Our ref: DOC20/683333

Senders ref: SSD 10422

Subject: EES Comments - New Berrima Brickworks SSD 10422 – Review of EIS – 416 & 524
Berrima Road, Moss Vale

Figure 3. Vegetation communities within the study area

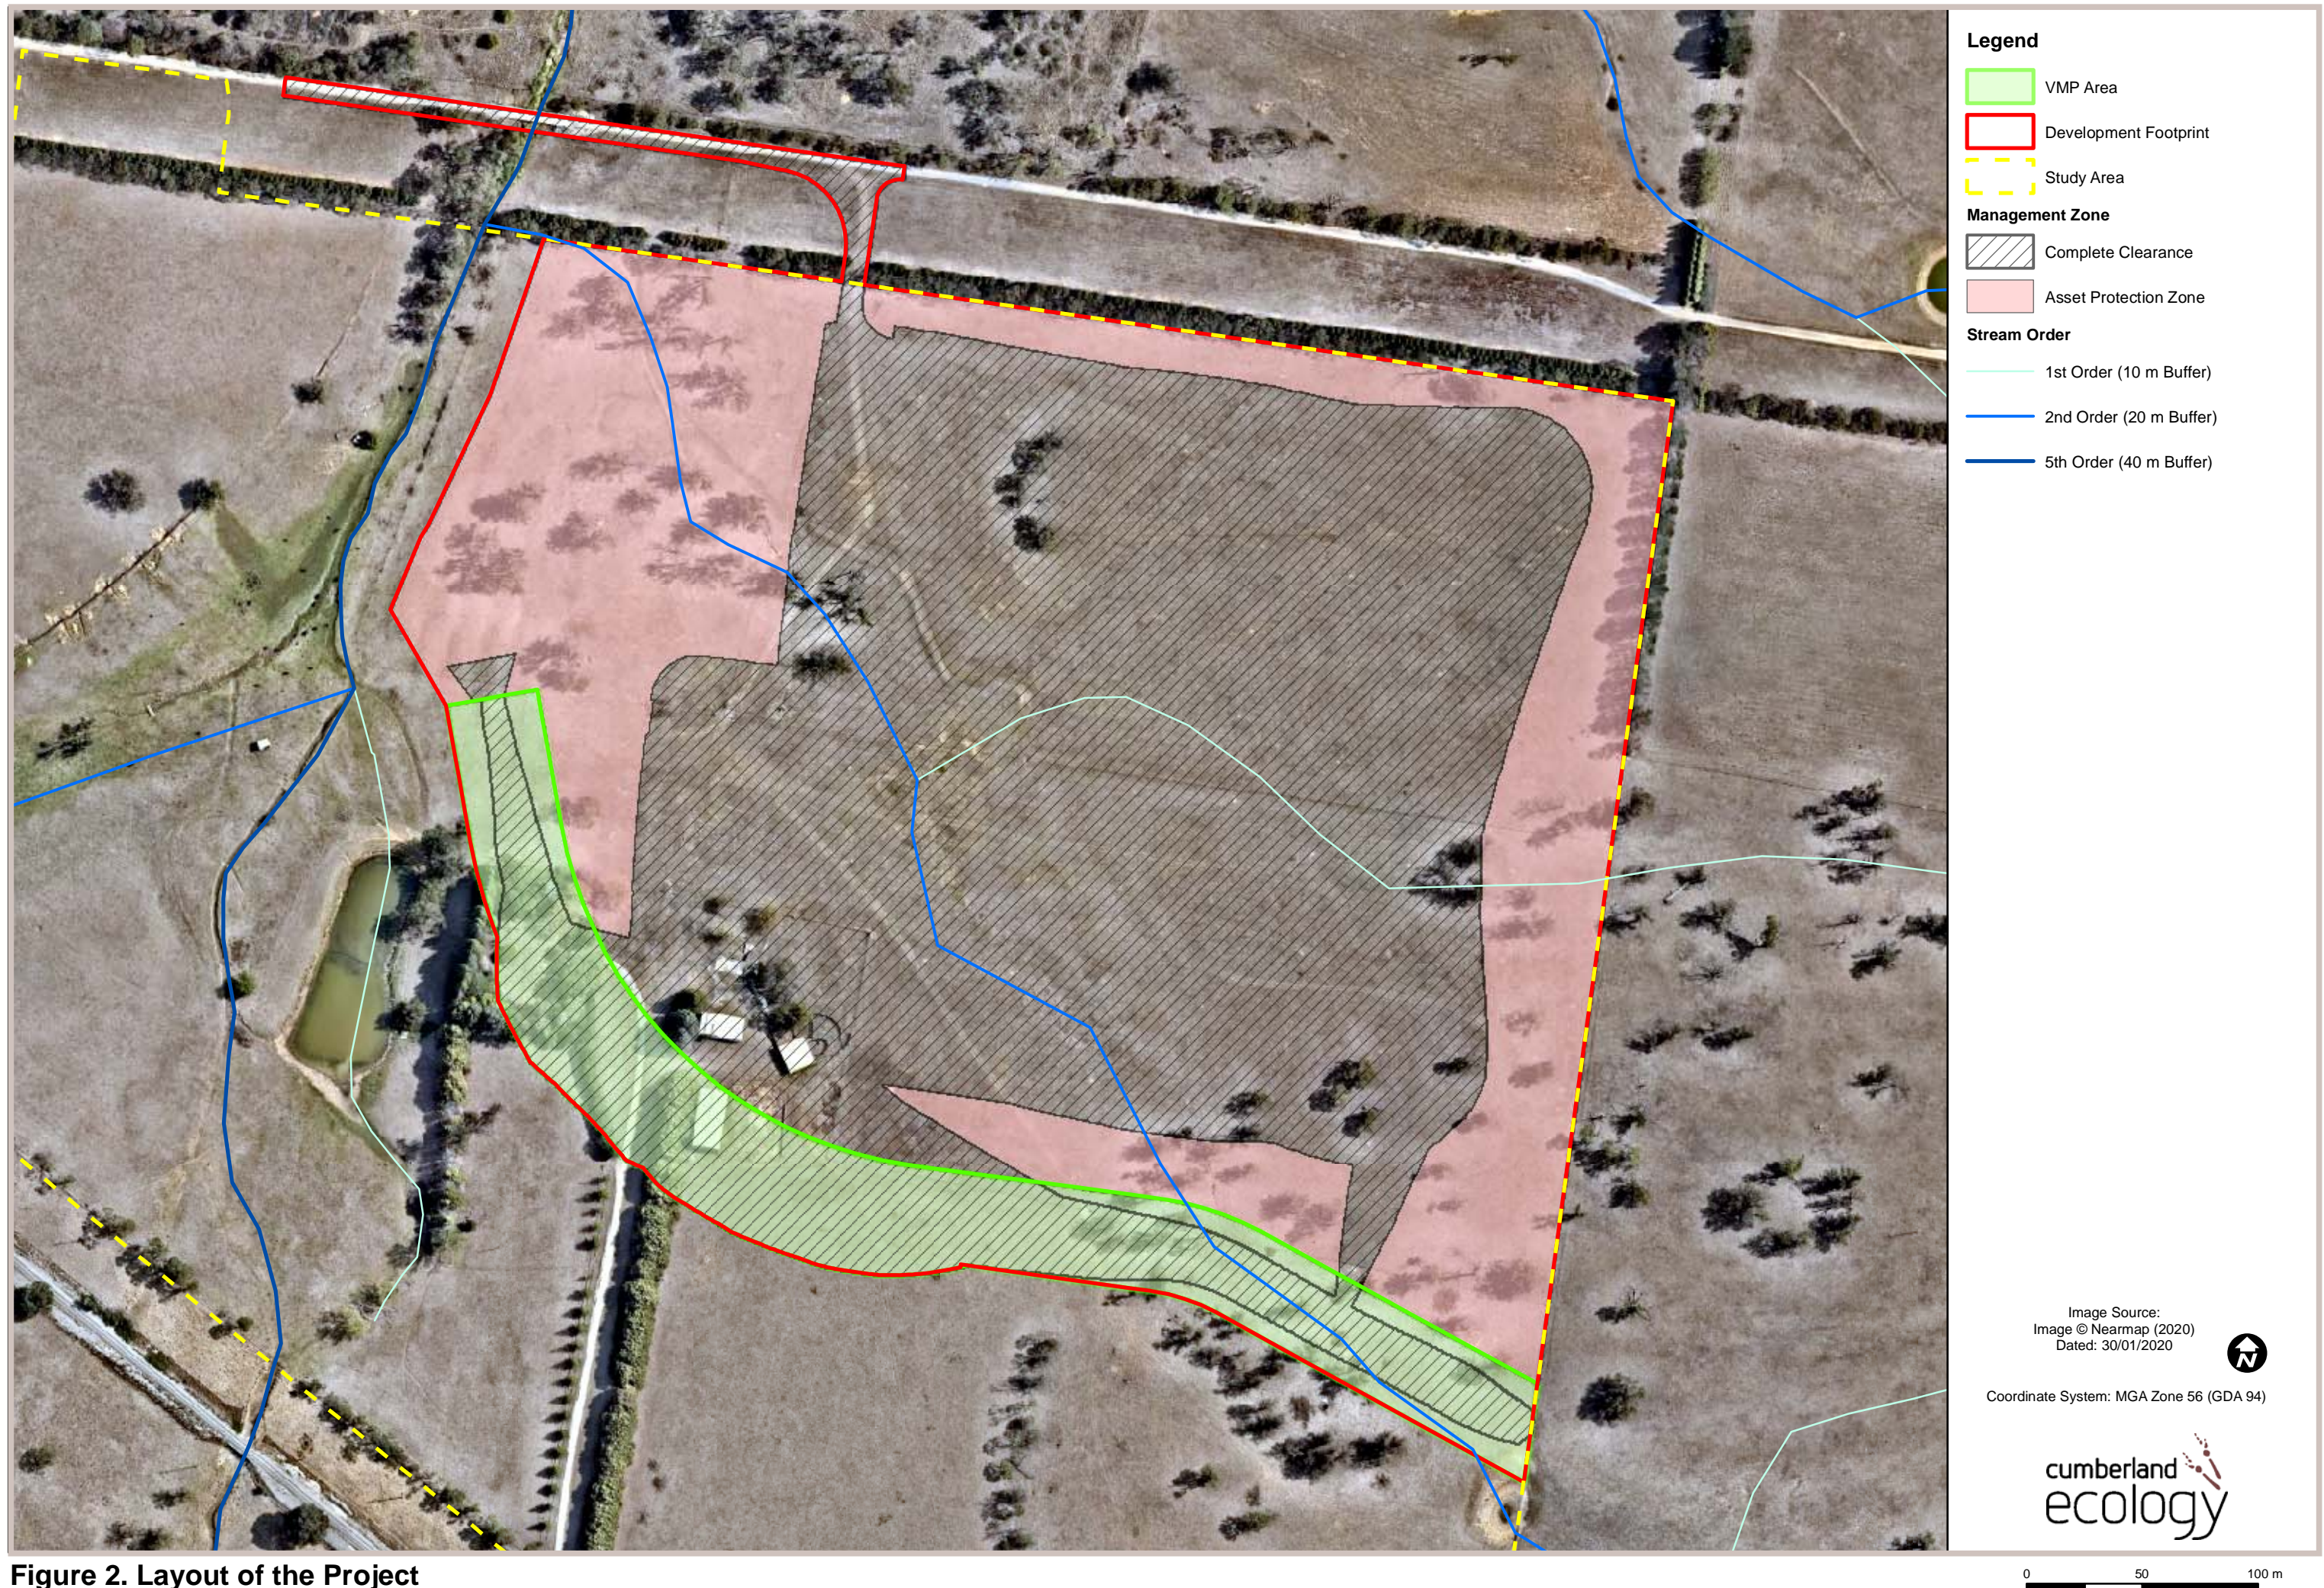
- Figures 3 and 8 indicate that “complete clearing” will occur in the VMP area. We request clarification whether this is the case as it appears this area is to be wholly revegetated and it is not clear if the existing paddock trees will be retained.
